Arun District Council
Arun Civic Centre
Maltravers Road
Littlehampton
West Sussex BN17 5LF
Planning & Building Control General
Enquiries

18th February 2011

Replacement dwelling
44 Broadmark Lane Rustington

DRW NO 8a SCALE 1/1250
LOCATION PLAN

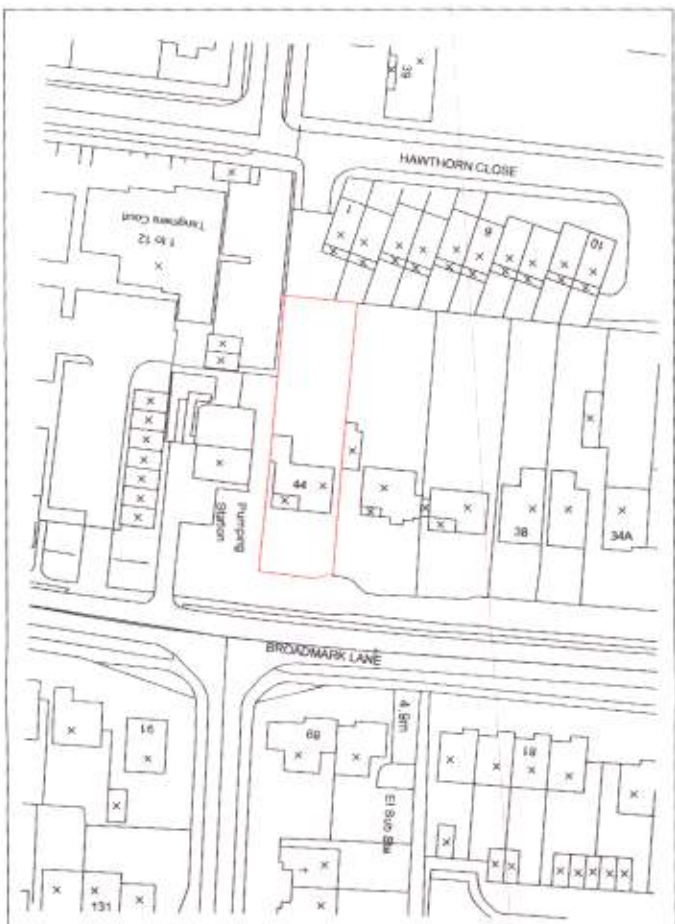
I require 1 electronic or 3 paper copies of a revised location plan showing Broadmark Lane as a named road.

Michael Pearce & Associates Ltd Chartered Surveyors - Architectural Consultants 3 West Ridings, East Preston, West Sussex. BN16 2TD	Tel 01903 786839 Mob 07812 195560 e-mail:michael@mpa-surveyors.co.uk	NEW DWELLING 44 BROADMARK LANE, RUSTINGTON	DRW NO 7a SCALE 1/500 SITE PLAN
--	--	---	---	--

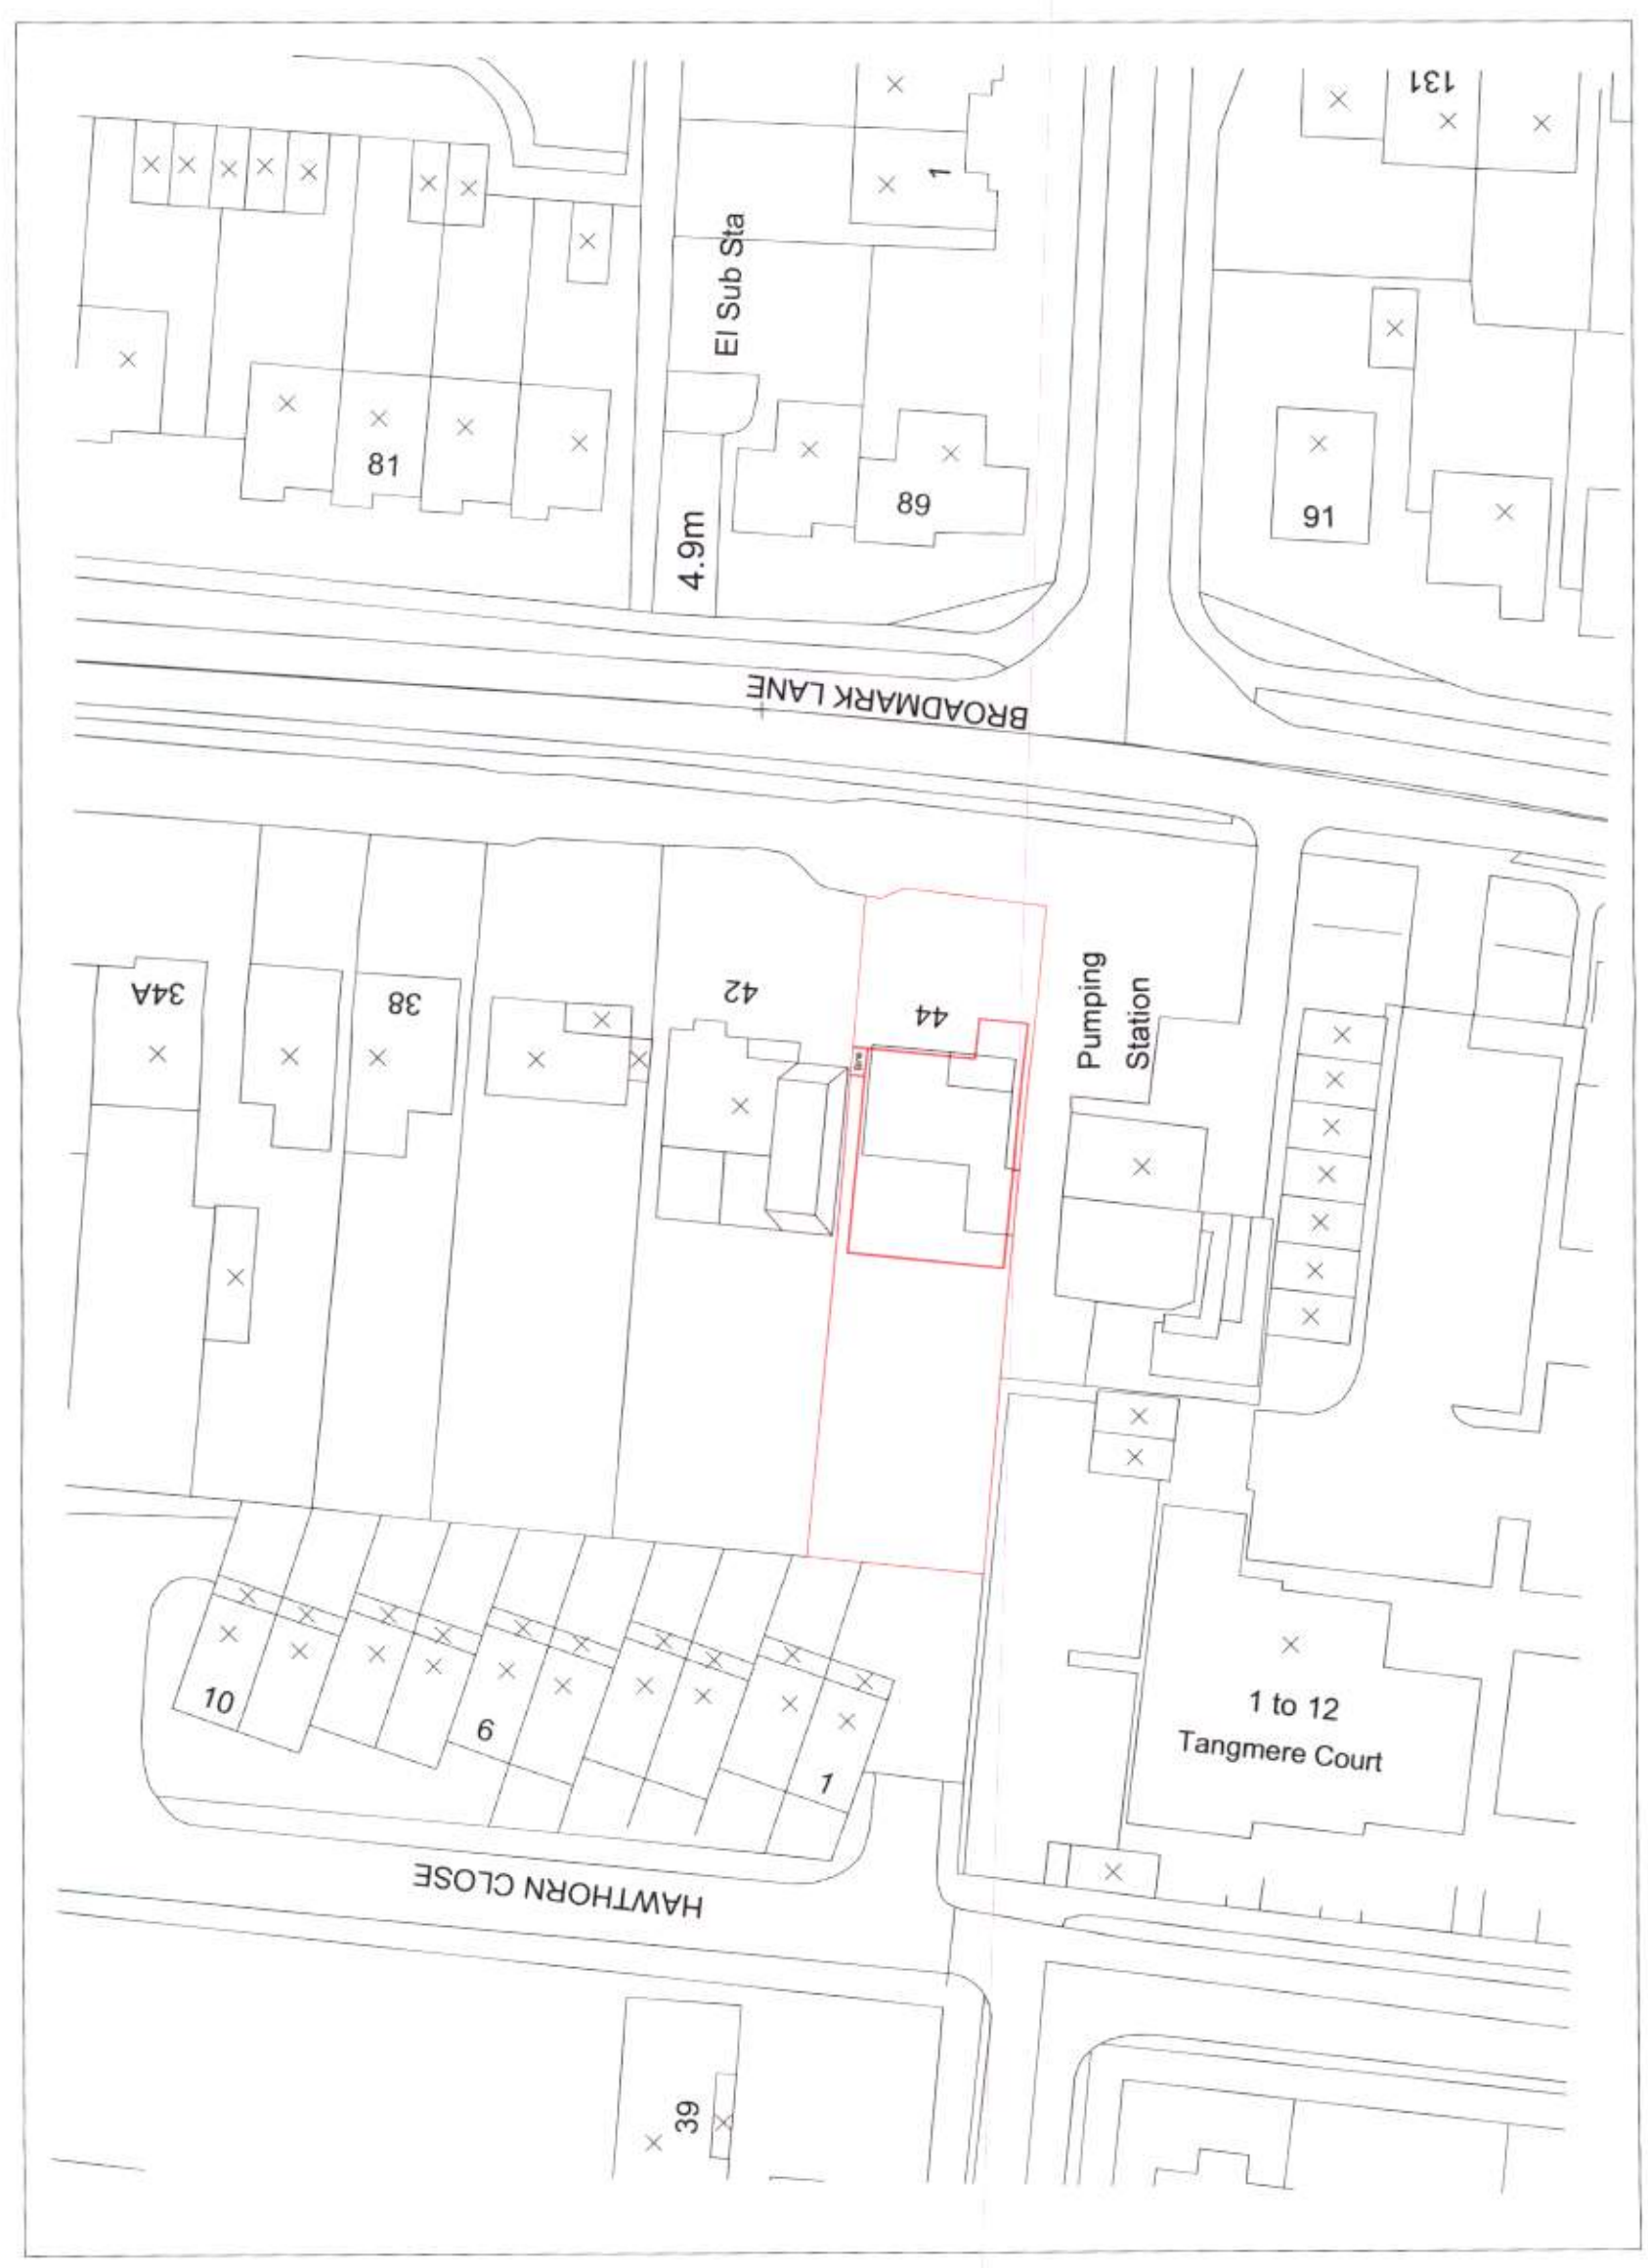
I require 1 electronic or 3 paper copies of a revised block/site plan showing the footprint of the existing dwelling marked as a dotted line and the waste storage and collection arrangements (as stated in the application form).

DRW NO 2a SCALE 1/50
 PROPOSED FIRST FLOOR PLAN

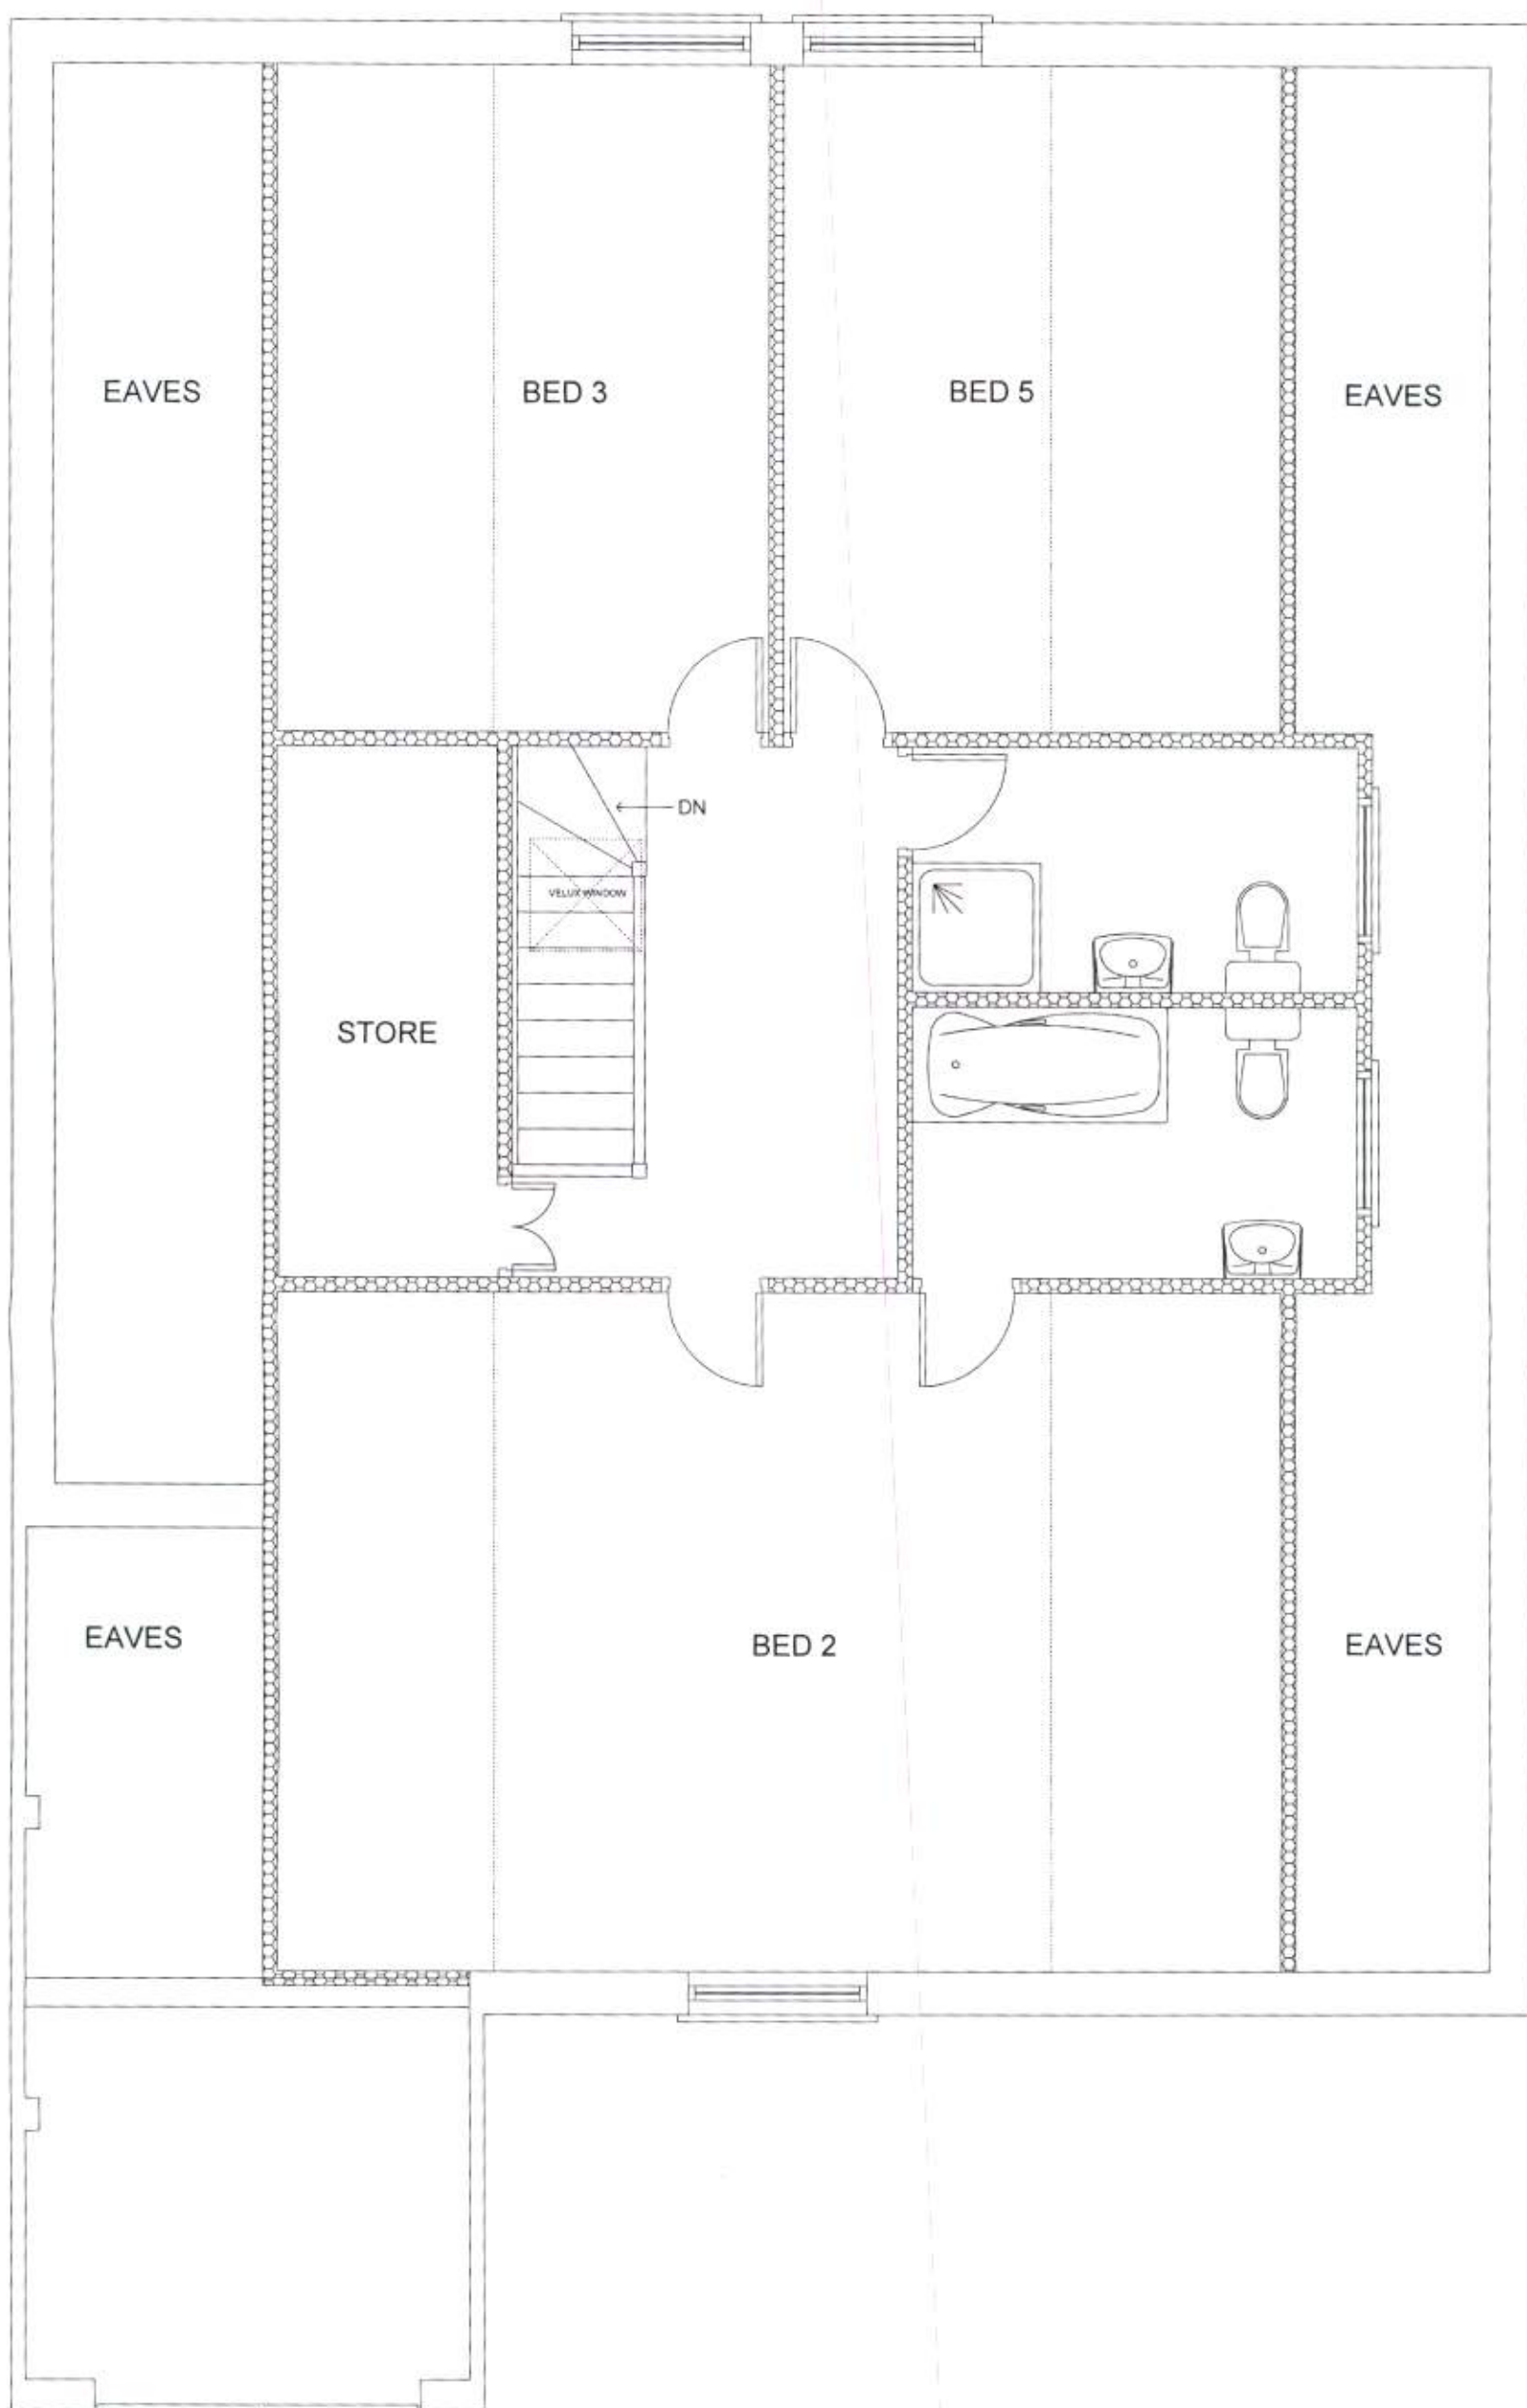
Please provide 1 electronic or 3 paper copies of a revised first floor proposed floor plan to show the velux window on the side elevation (south).
